City of Ryde Submission

MEEP - Schools Project Modification (SSD-9343-Mod 5)

Seeking to amend conditions E1, E2 and E3 to clearly define school, community and external use of the school premises

Submission Date: 23 May 2023

CAR PARK LEVEL PLAN

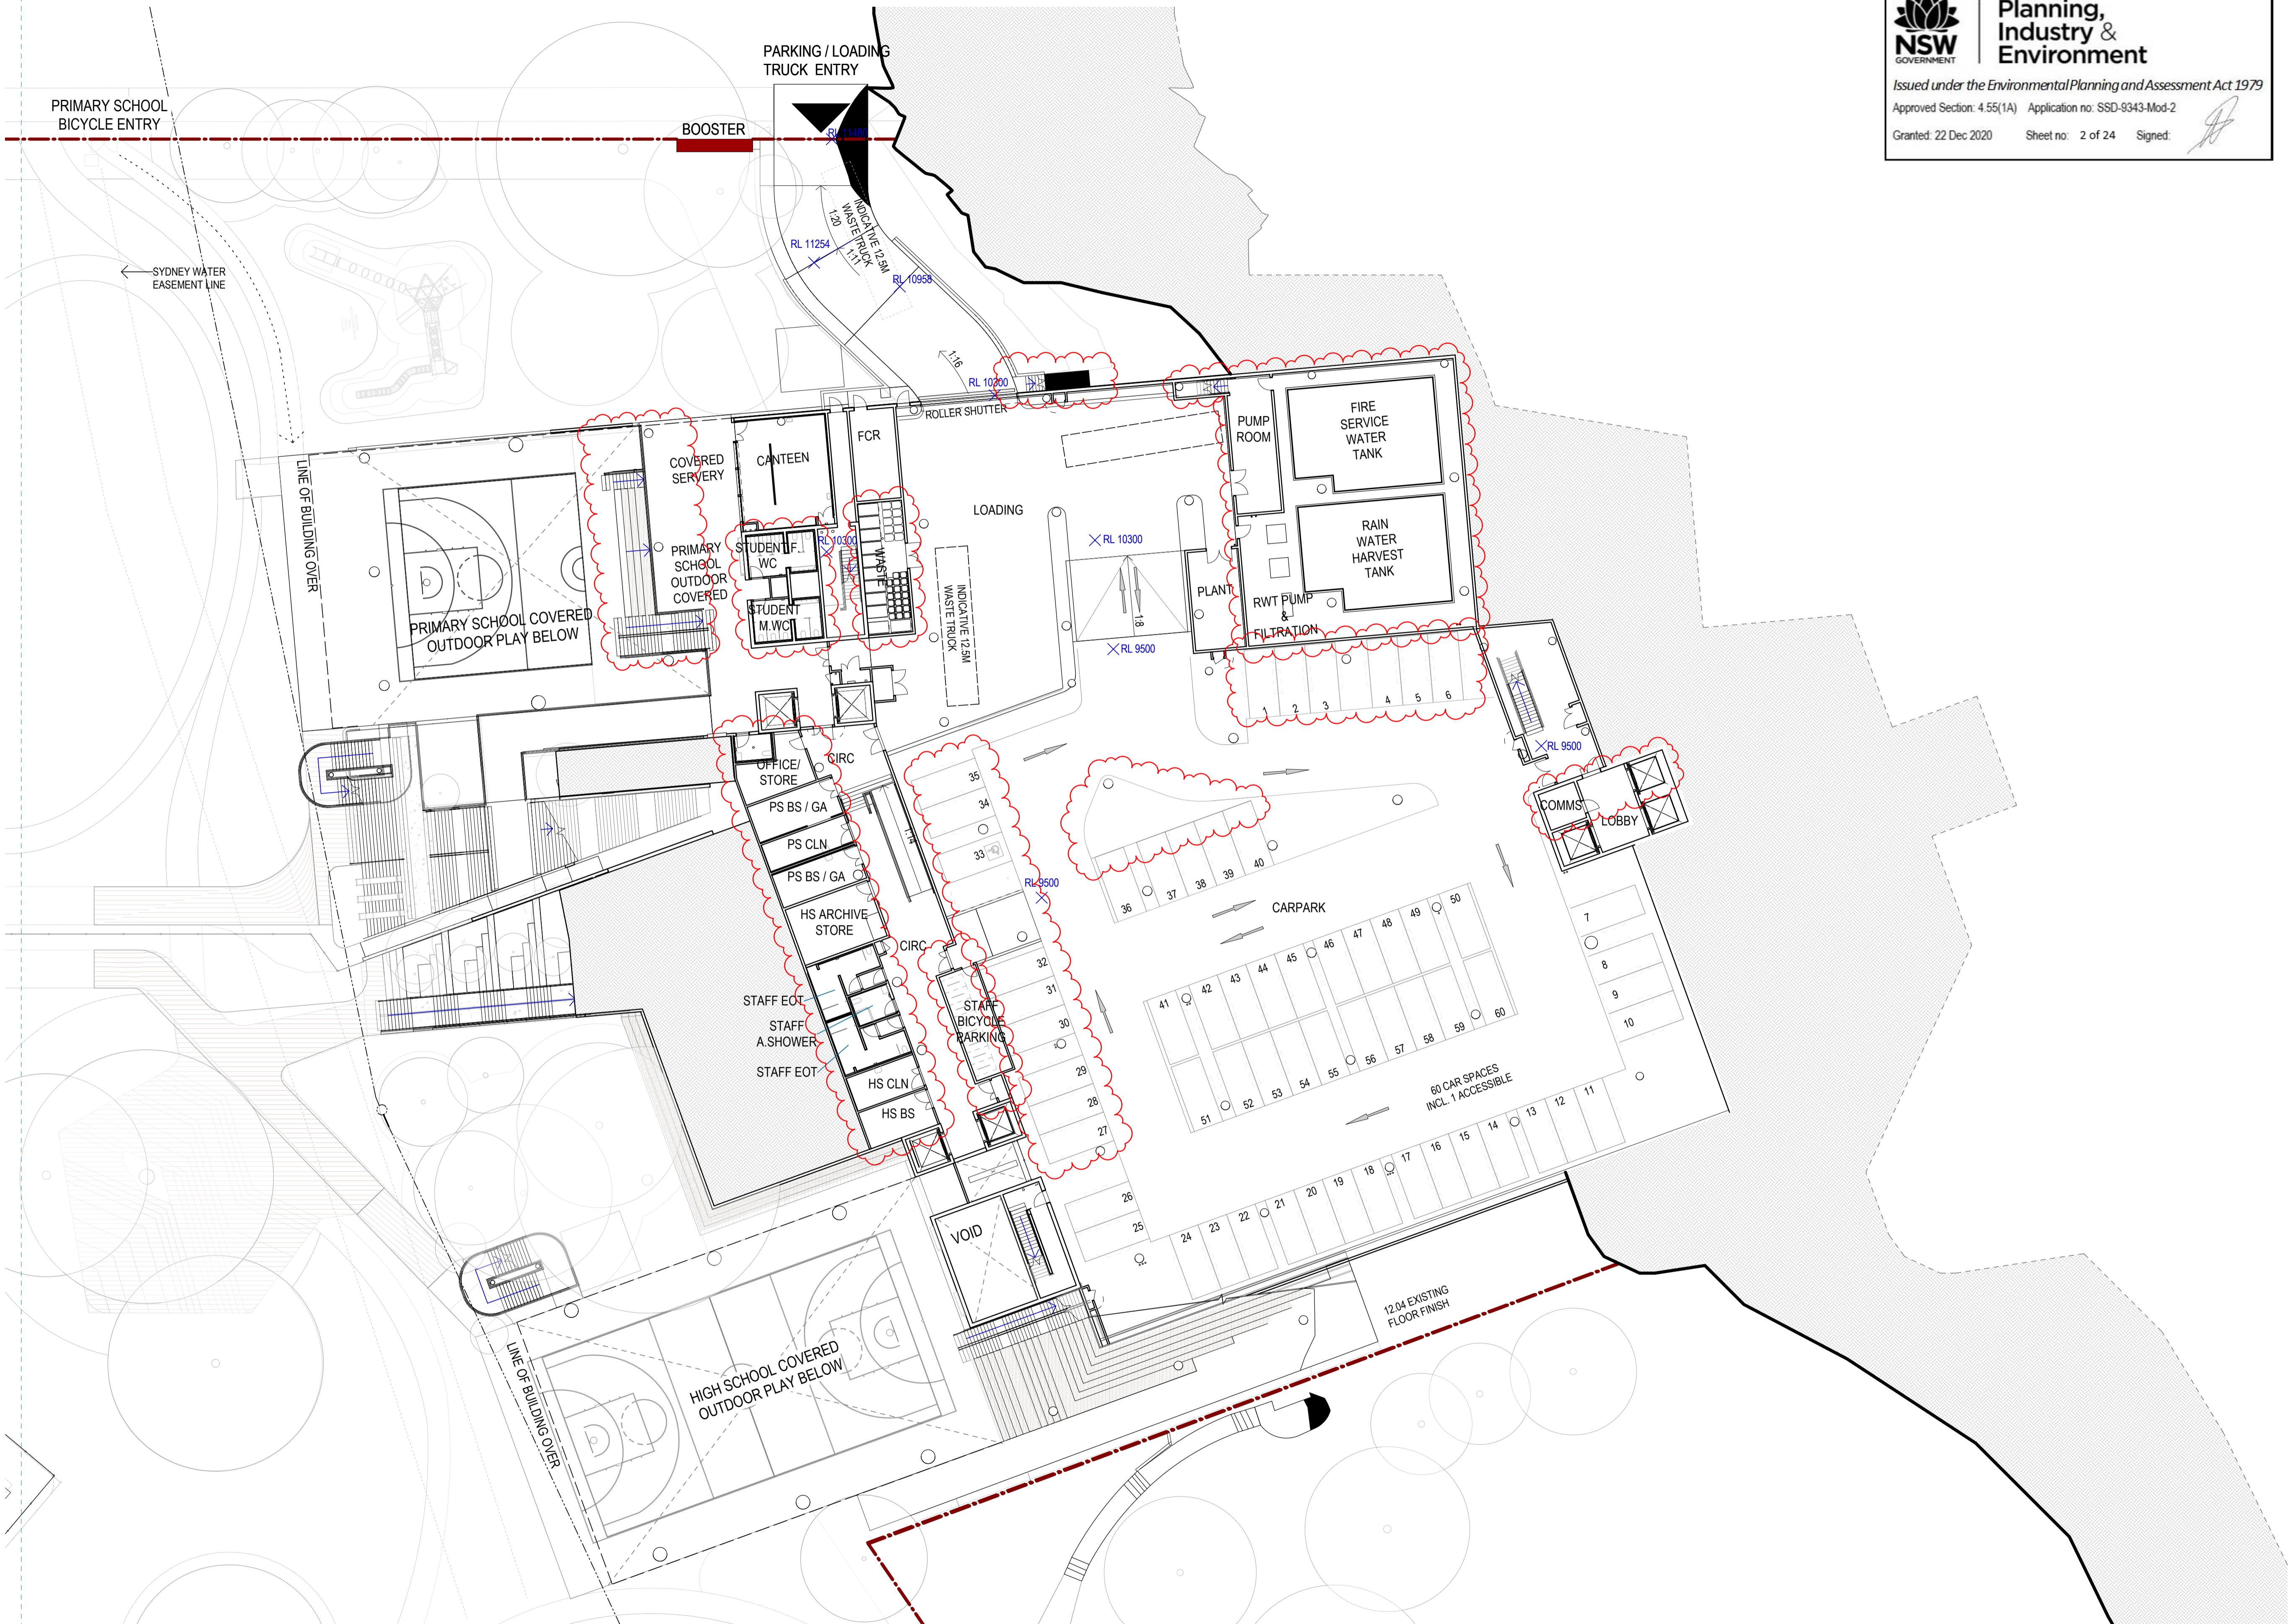
School's basement carpark (60 parking spaces) be available for public use

The TPA report undertook a parking demand survey of the publicly available on-street parking spaces, within approximately 400 metres of the subject site east of the rail corridor on Tuesday 20 August 2019 from 6:00am to 11:30pm. The results of the parking demand survey show that outside of standard school operational hours, the occupancy is between 50% and 65%. On this basis, the TPA report concludes that there will be adequate capacity on-street, outside of standard school operating hours, to accommodate the parking demand associated with out of hours events. It is noted that most of the adjoining properties opposite the subject site are light industrial developments. As a result, more on-street parking will be available after closing of the businesses, and consequently, it is expected that the parking demand associated with out of hours events can be readily accommodated on street. However, it is expected that some of the parking demand may still spill over to the residential streets. A loss of parking in the residential areas is a major concern for City of Ryde and it will impact on the residents in these areas. To reduce this impact, it is recommended that an additional condition be imposed to make the school's basement carpark (including 60 parking spaces) available for public use at any time during the out of hours events.

(i) At all times where the school is used for out of hours events, the car parking within the basement of the school is to be open and available for public use.

LEVEL 2 FLOOR PLAN

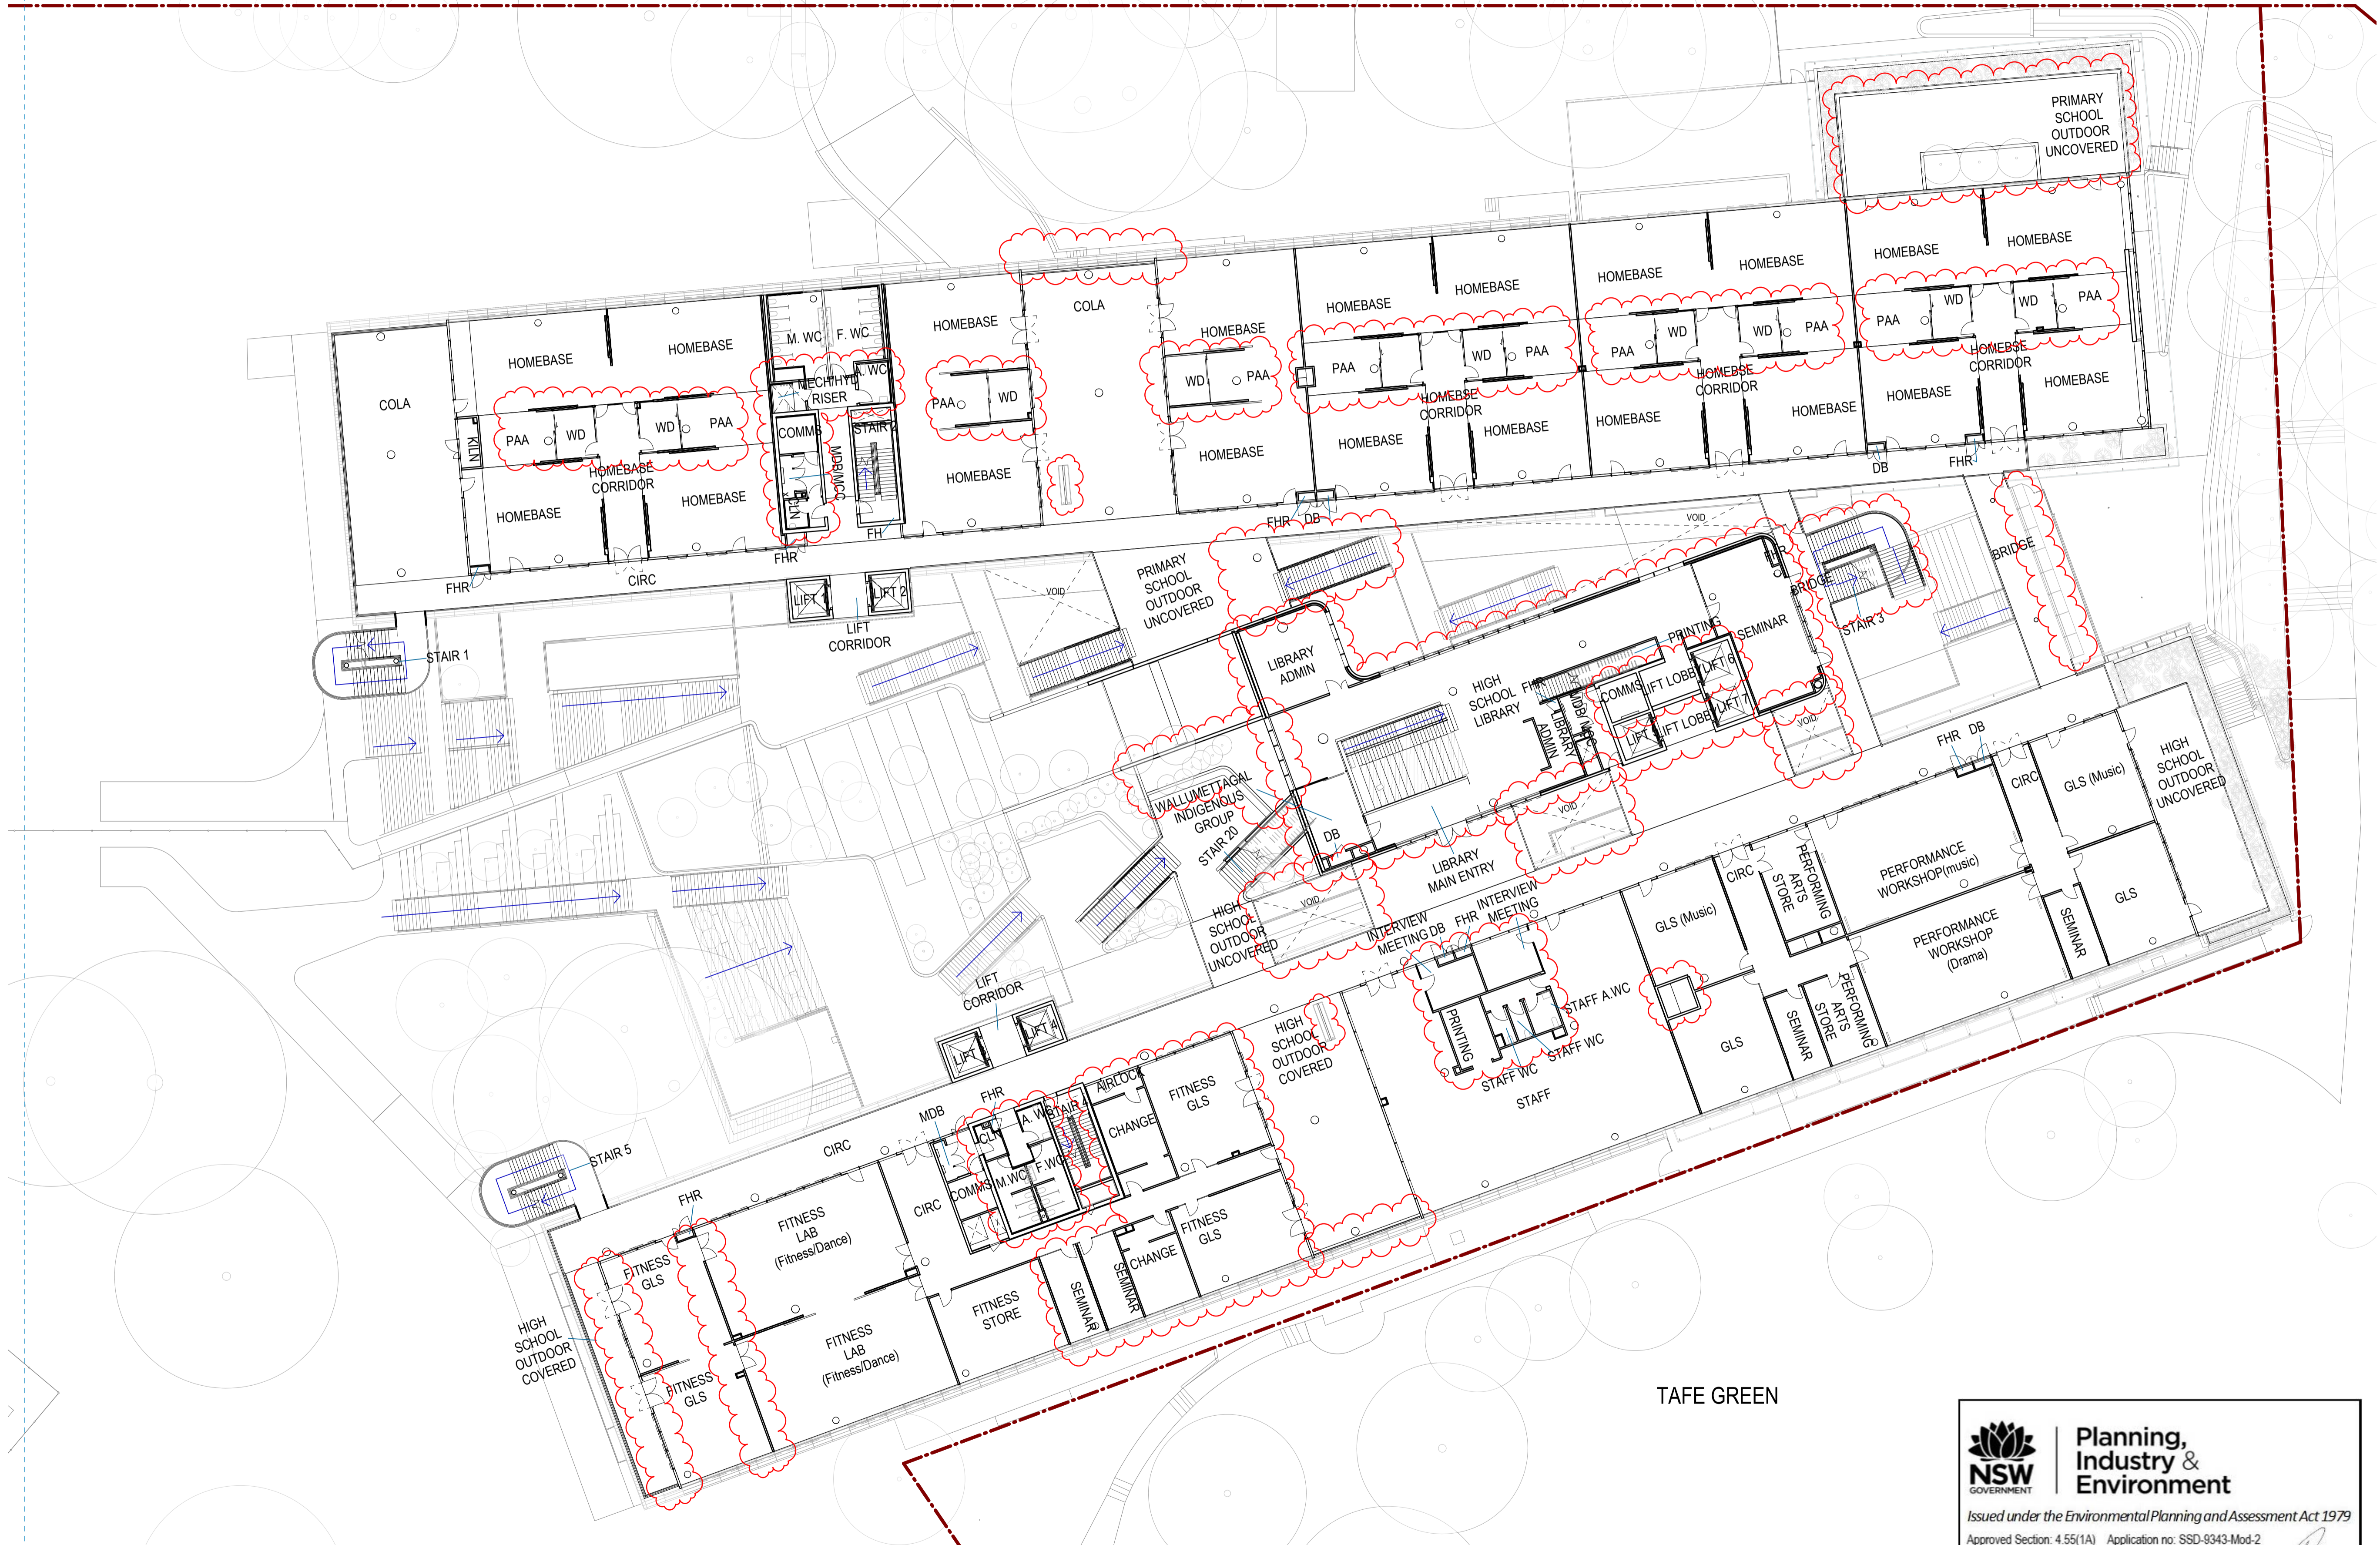
(f) Primary and High School uncovered areas on Level 2 are not to be used by external parties.

(f) Primary and High School uncovered areas on Level 2 are not to be used by external parties.
